July 23, 2026

El Paso County Planning & Community Development
Attn: Miranda Benson, Associate Planner
2880 International Circle
Colorado Springs, CO 80910

**SUBJECT: Monument Academy East Campus – 4303 Pinehurst Circle
Site Development Plan – Letter of Intent**

LANDSCAPE PLAN - AREA 'C'

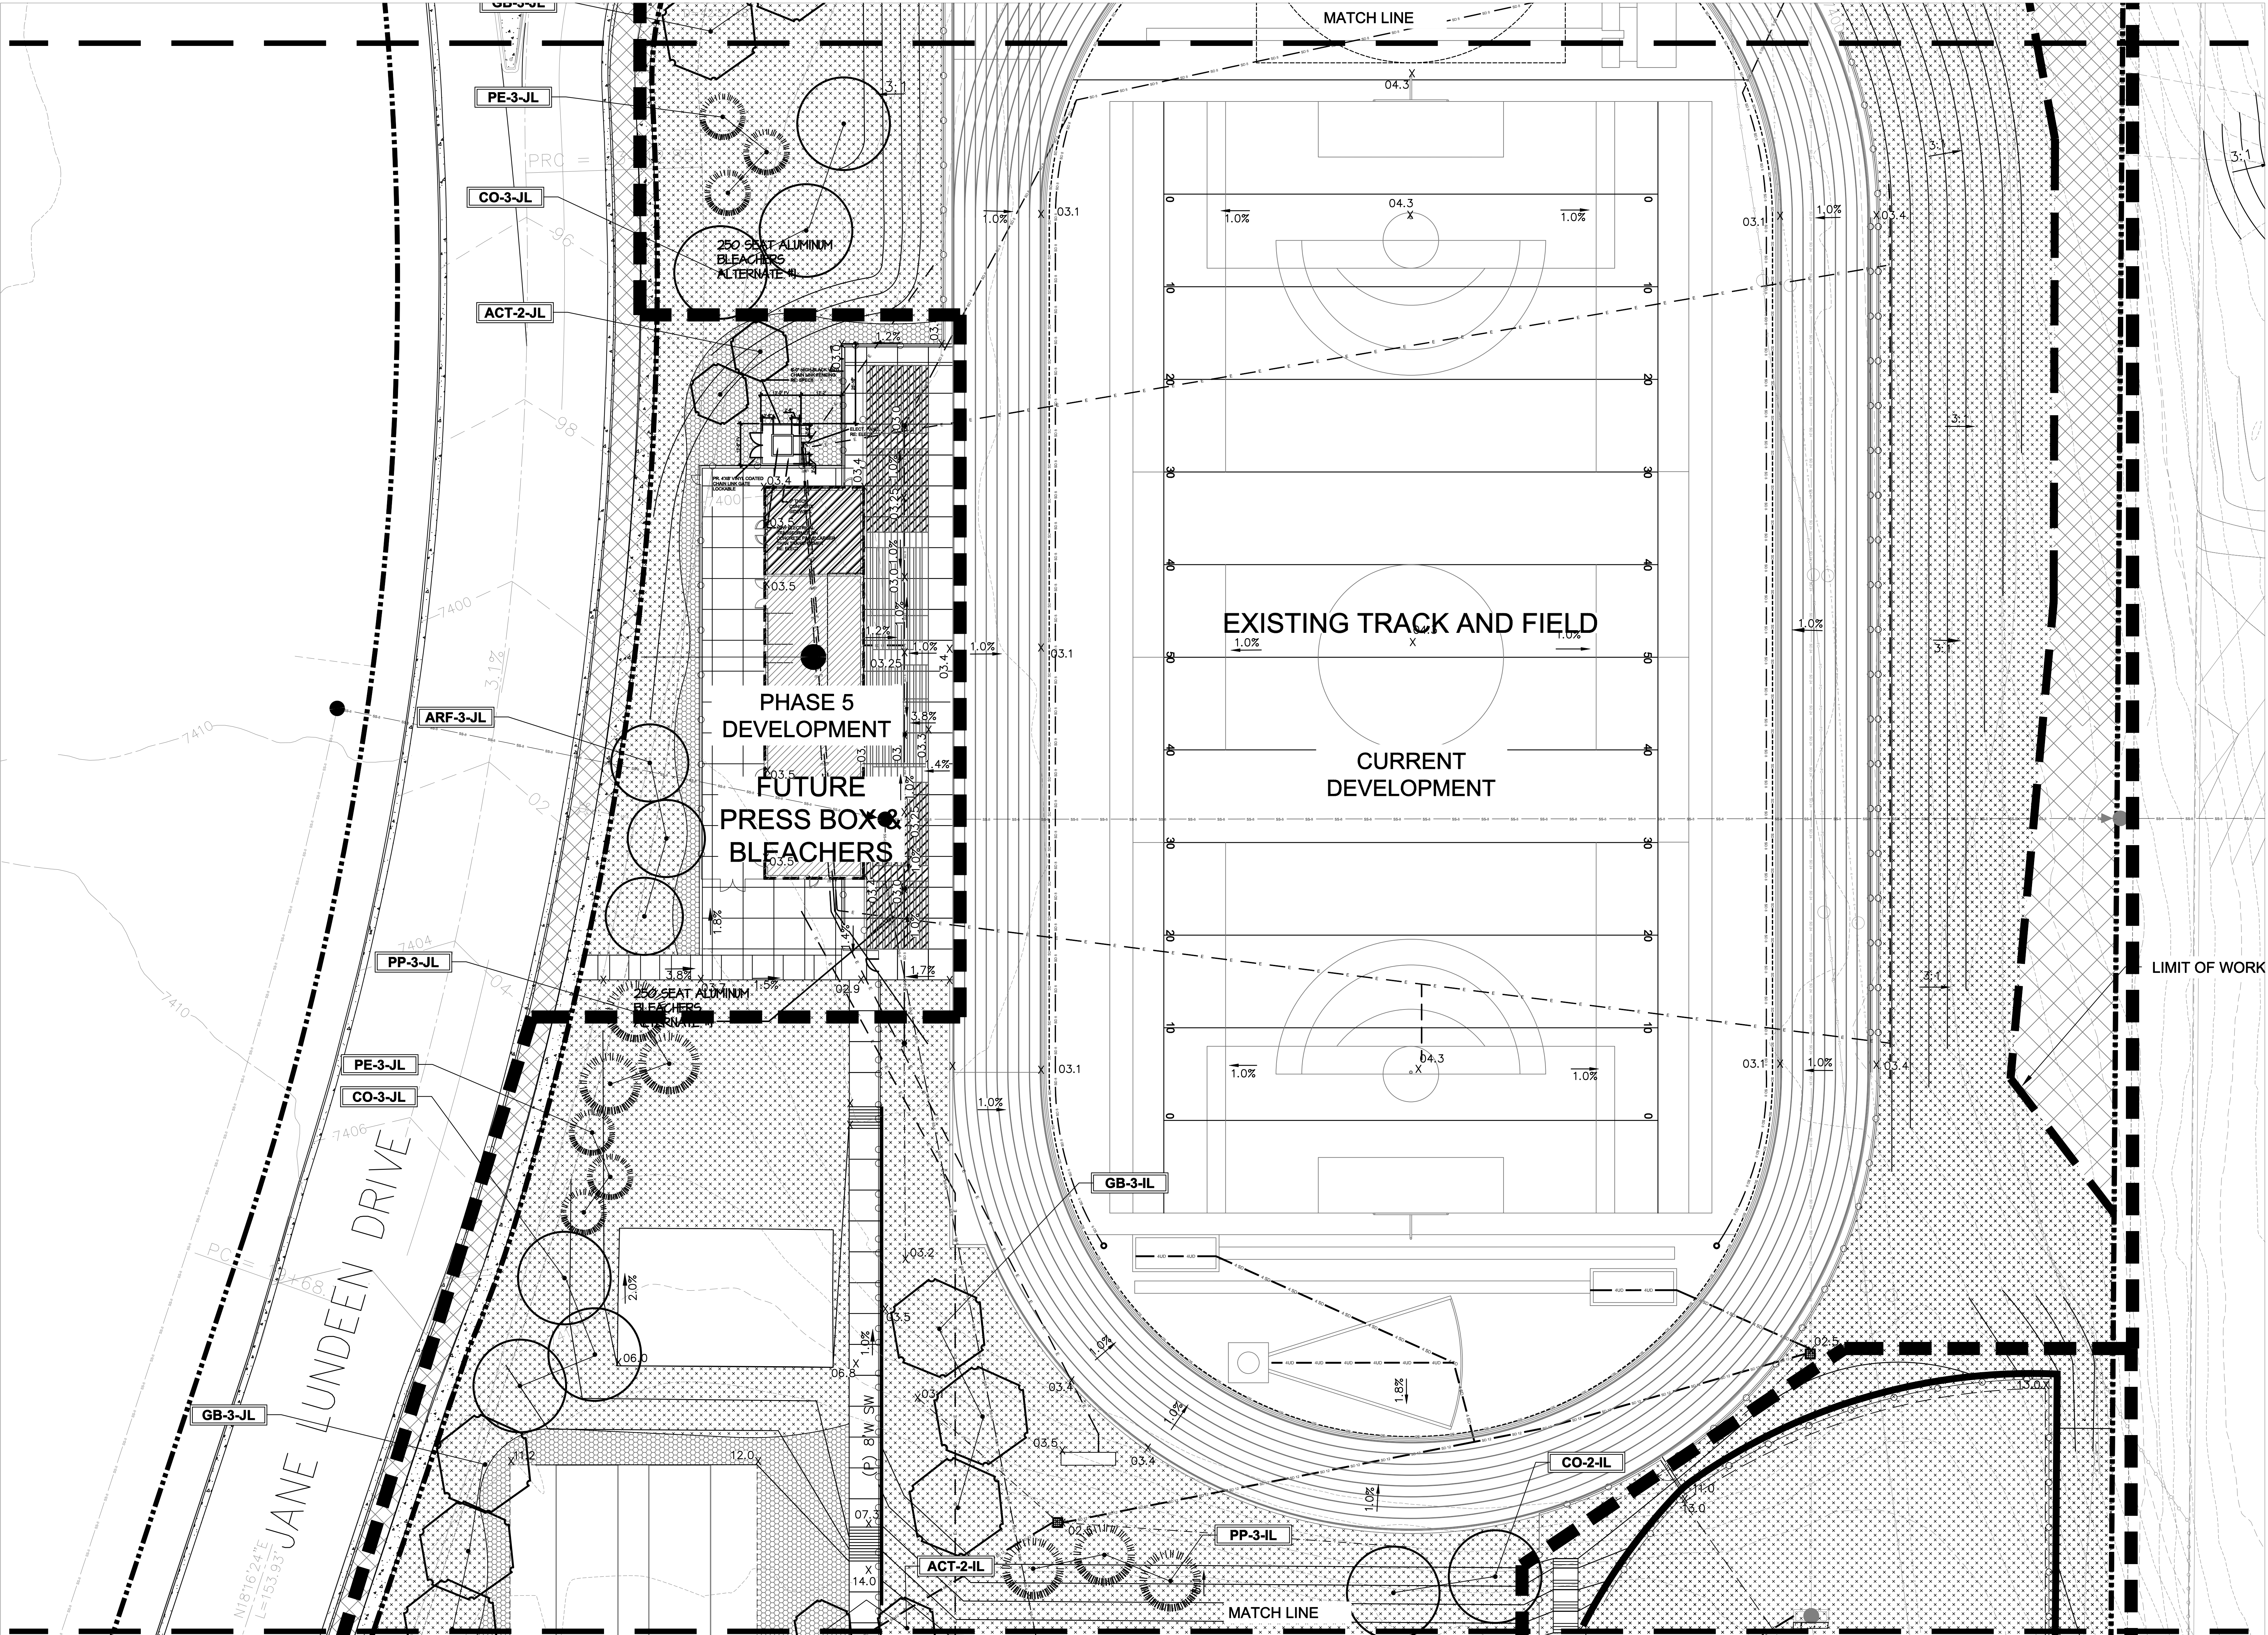
1. **Section: 6.2.2.E.2.a-b. Requirement for Non-Residential Uses, Minimum required Landscape interior area and Tree Count:** Monument Academy is proposing an alternative landscape plan with a reduced interior tree count provided based on limited resources. The proposed site design adequately meets the functional needs of the school and provides appropriate aesthetic landscaping. PPR199 allowed for a reduced number of trees. Internal landscaping was not waived.

2. **Section 6.2.2.C.2. Parking Lot Islands: Islands, fingers, and corners are required to be incorporated into all parking lots of 15 parking spaces or more in area. One island shall be provided for every 15 spaces.** Monument Academy is proposing an alternative landscape plan deleting the tree islands or an appropriate alternative design that meets the intent of the Code. PCD Director does not have the authority to diminish the total requirement. Include islands or an appropriate alternative design that meets the intent of the Code. to snow plowing in the parking lot. The proposed site design adequately meets the functional needs of the school without having tree islands with curb and gutter.

4. **Section 6.2.2.C.5. Required Parking Lot Screening: 36" landscape shrubbery screen.** Monument Academy is proposing an alternative landscape plan deleting the 36" shrubbery parking lot screening requirement. PCD Director does not have the authority to diminish the total requirement. Provide parking lot screening or provide detail of an alternative proposal. The Landscape Plan appears to show landscaping around the parking lot areas. boundary. Due to the large size of the parking lot, the proposed site design appears to show landscaping around the parking lot areas. stacking concrete parking lot screening requirements, while providing an appropriate program of landscape plantings for the school site.

5. **Section 6.2.2.D. Privacy fence between residential / non-residential uses.** Monument Academy is proposing an alternative landscape plan deleting the privacy fence typically required between residential and non-residential uses. PCD Director does not have the authority to diminish the total requirement. Roadway landscaping and buffering between differing uses may overlap. The Landscape Plan appears to show landscaping along all property boundaries. site boundary, existing residential development, and Monument Academy. Fencing is not required: non-residential

9 OVERALL NORTH EXTERIOR ELEVATION

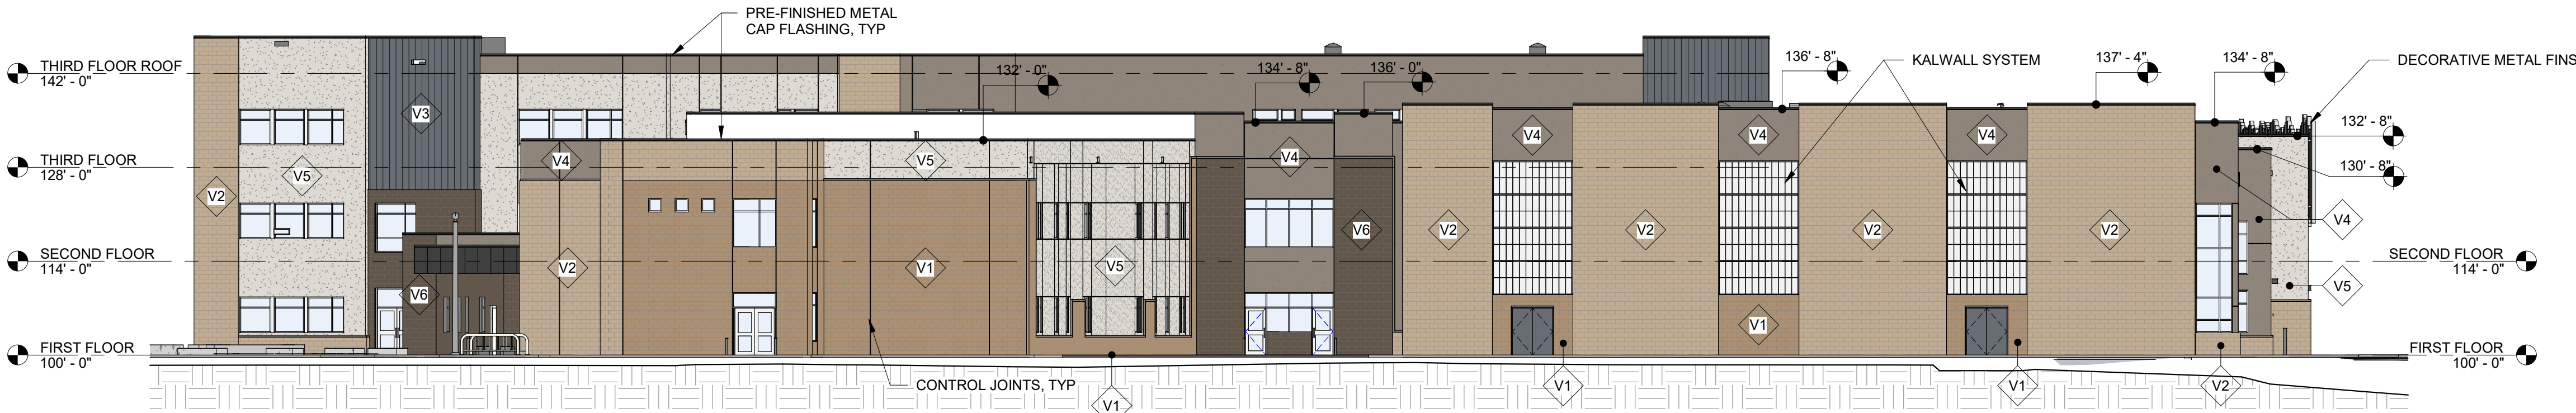
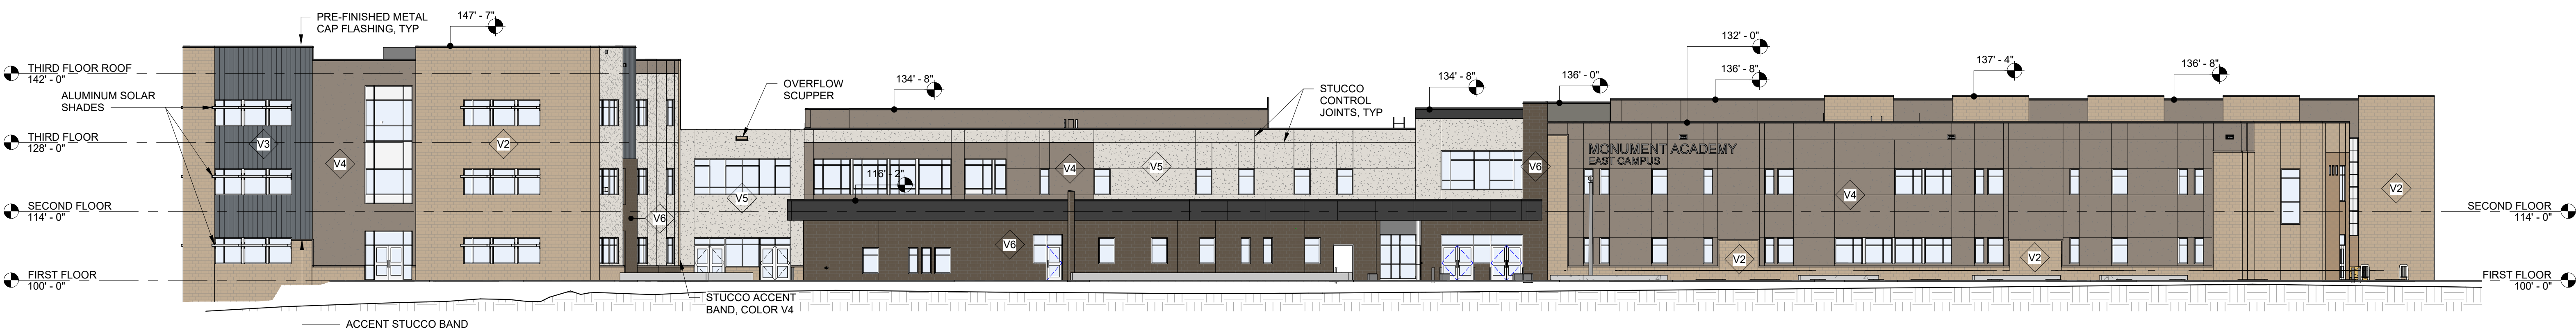
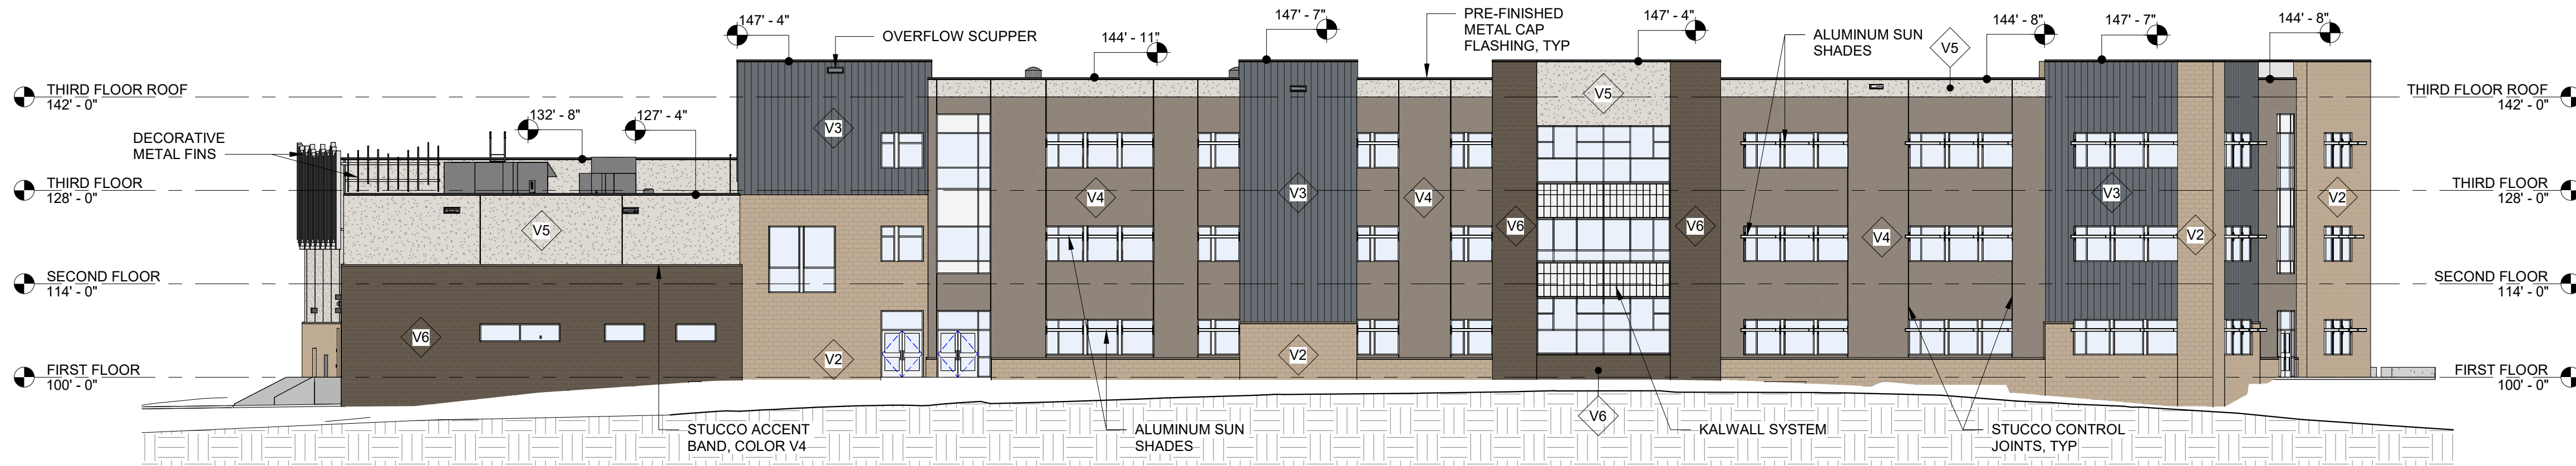
Elevation plans show a building height of 42' (not including architectural feature). This will require a request to the Board of Adjustment for a Dimensional Variance. Please contact MirandaBenson2@elpasoco.com.
